Rezoning Transportation Analysis

Petition Number: 2020-134

Reviewer: Kevin Parker, PE

Date	Description
10-20-2020	First Review (KP)

RZ-2.0

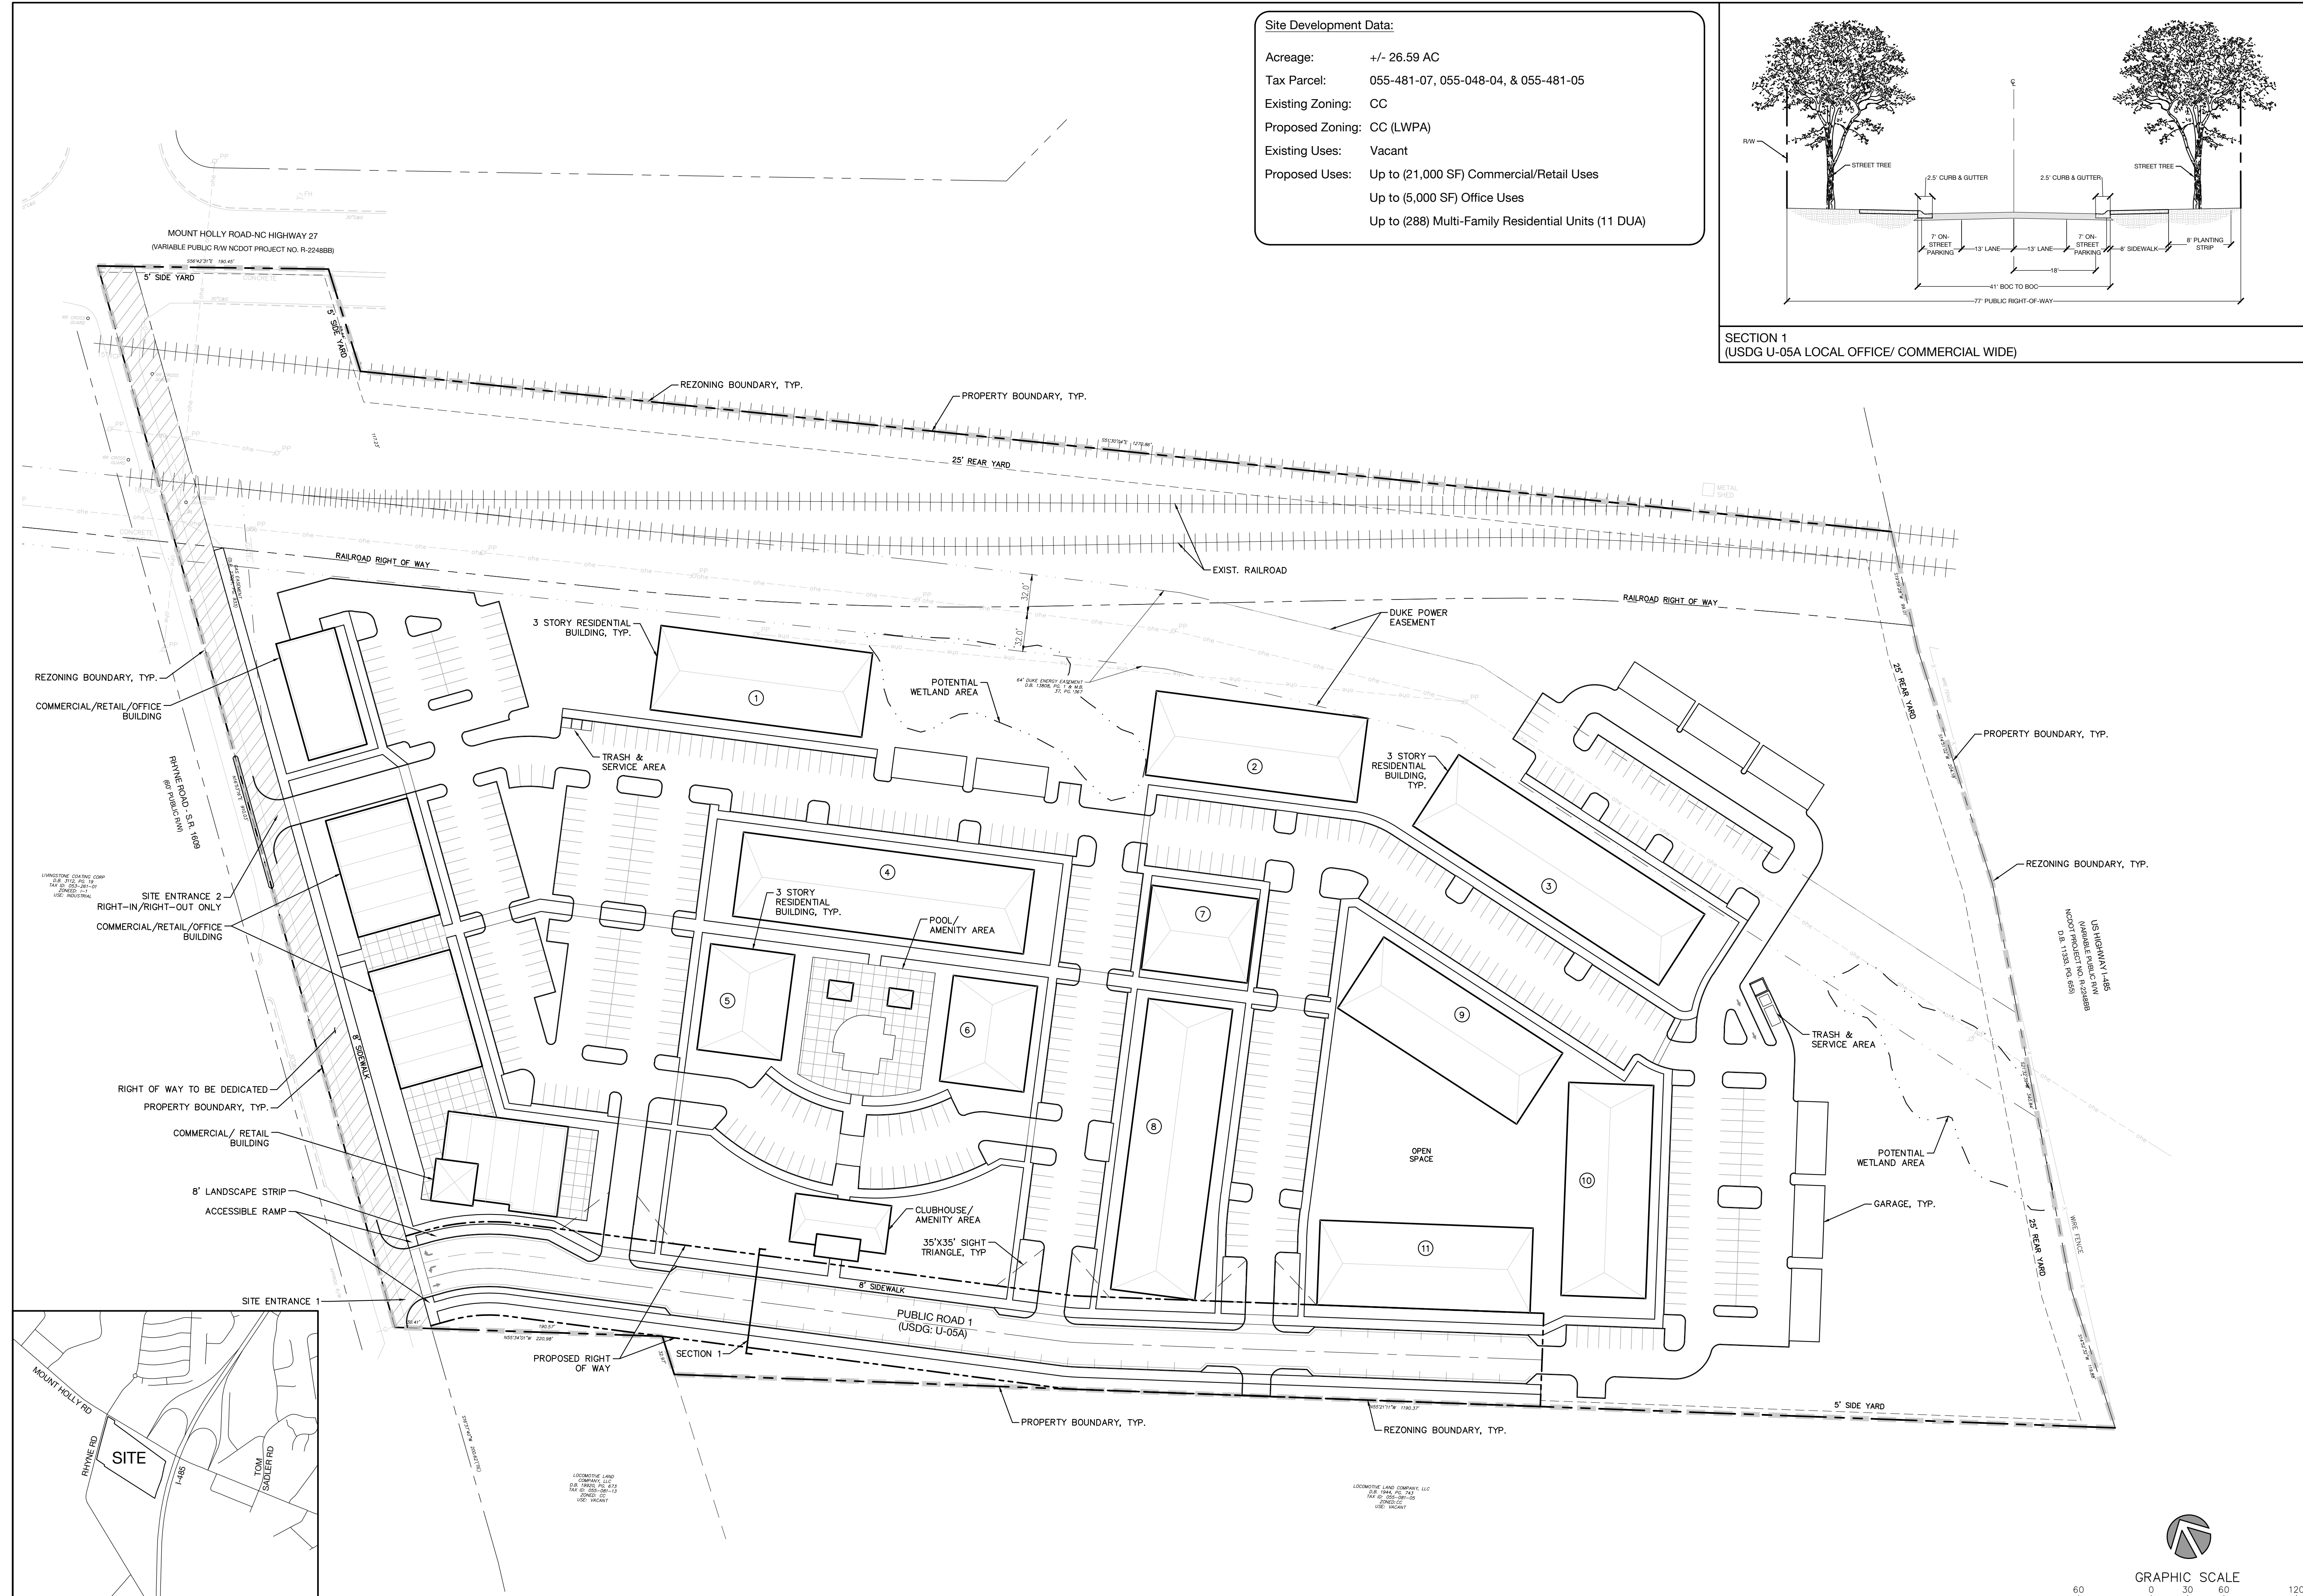
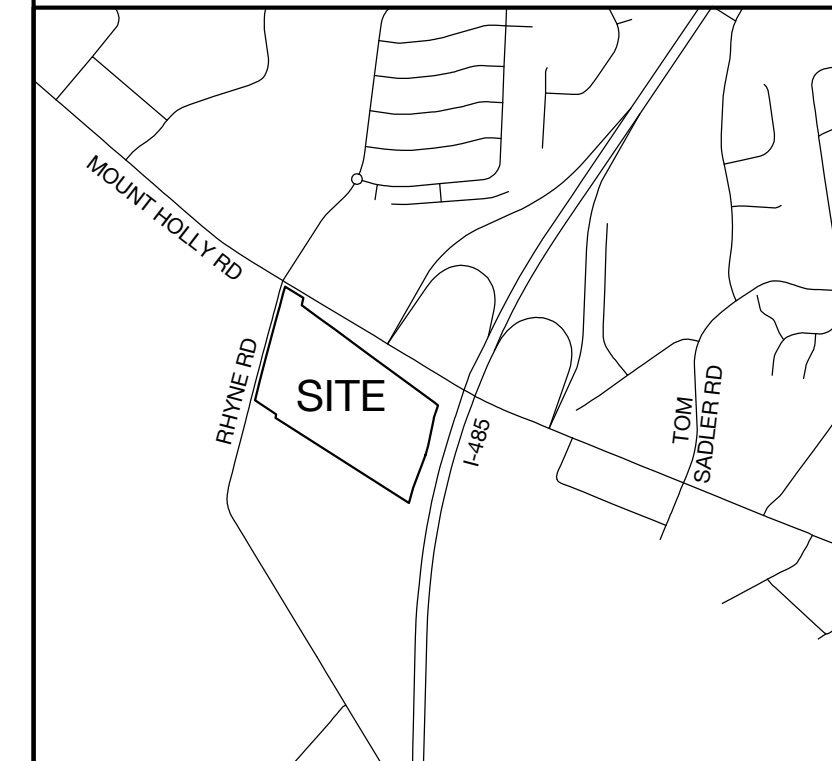
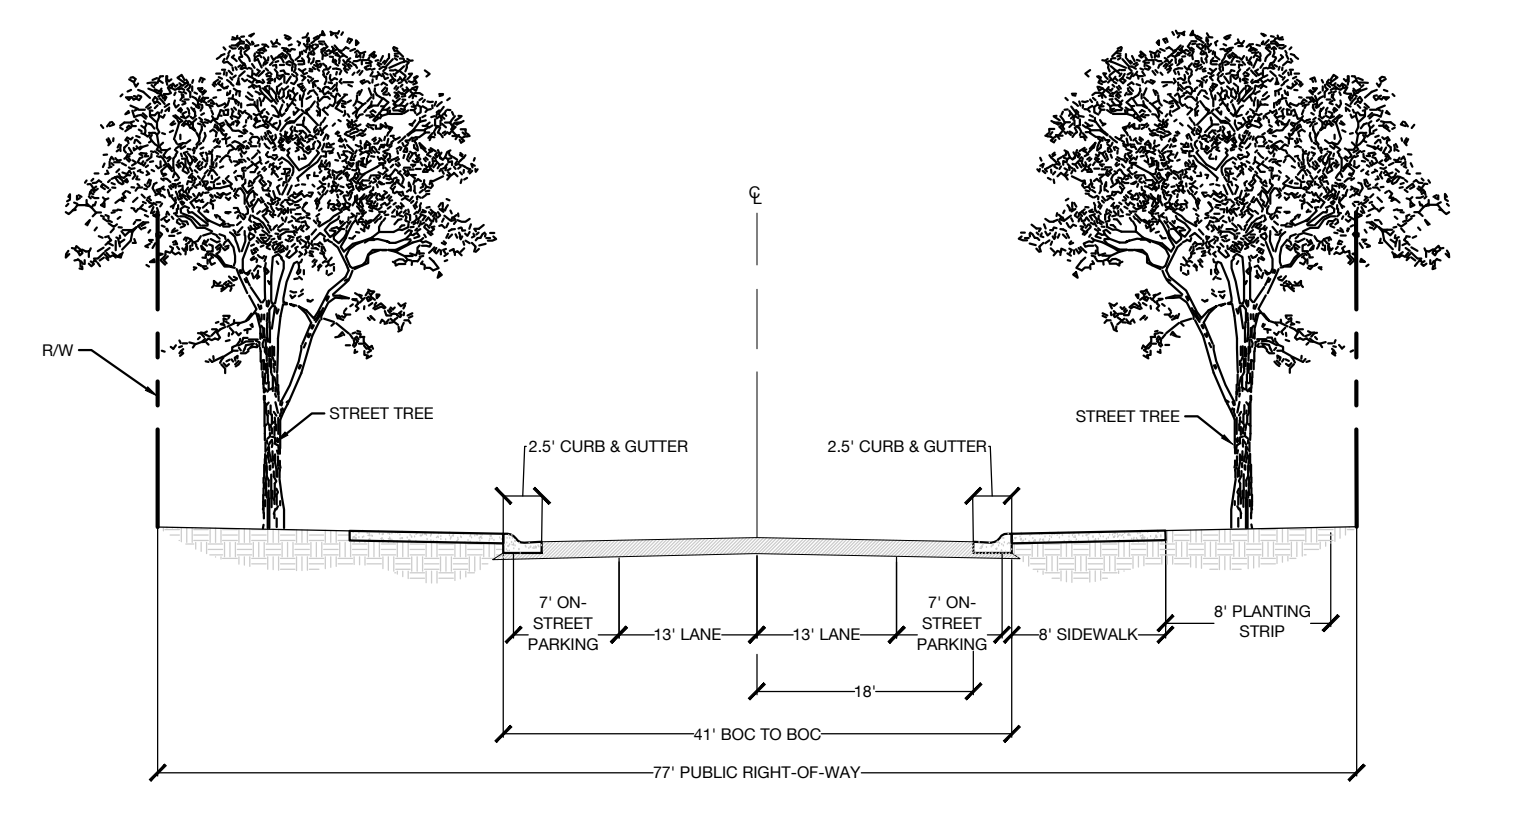
1. Curb line:

- a. **Mt. Holly Road:** The future location of curb and gutter will be located 33-feet from centerline to the back of curb.
- b. **Rhyne Road:** The location of curb and gutter will be located 19-feet from centerline to the back of curb.

Label and dimension the curb and gutter from the centerline for each road.

3. Right-of-Way Dedication:

- a. **Mt. Holly Road:** Revise the site plan and conditional note(s) to commit to dedicate 55-feet of right-of-way from the road centerline.
- b. **Rhyne Road:** Revise the site plan and conditional note(s) to commit to dedicate 41-feet of right-of-way from the road centerline.

The site plan should label and dimension the right-of-way from the road centerline.

4. Revise the site plan and conditional note(s) to commit to construct an 8-foot planting strip, and 12-foot multi-use path along the site's Mt. Holly Road and Rhyne Road frontages per Chapter 19 and the City's WALKS and BIKES policies. The site plan should label and dimension both items from the back of curb and gutter and road centerline.

5. Revise the site plan to show, label, and dimension the center lane median, on Rhyne Road, in front of Site Entrance 2, that will direct the right-in right-out movement(s). Also, include the commitment to construct this center lane median in the conditional notes.

6. Revise the site plan and conditional notes to commit to the construction of a three-lane cross section, as shown below, along the site's Rhyne Road frontage. Add to the conditional notes that center turn-lane storage and tapers will be coordinated with NCDOT during plan permitting.

- a. ***Advisory Comment*:** In accordance with the construction of the 12-foot multi-use path as noted in item 4 of this CDOT memo, the 5-foot bike lane, as depicted in the cross section below, may be excluded.

7. Add a note specifying dedication and fee simple conveyance of all rights of way to NCDOT before the site's first building certificate of occupancy is issued. CDOT requests right of way set at 2' behind back of sidewalk where feasible.
8. Add a conditional note specifying all transportation improvements will be approved and constructed before the site's first building certificate of occupancy is issued. The petitioner may phase transportation improvements if said improvements and phasing are explicitly described in site plan notes.
9. ~~Resolved-Sample format for comment that is resolved~~
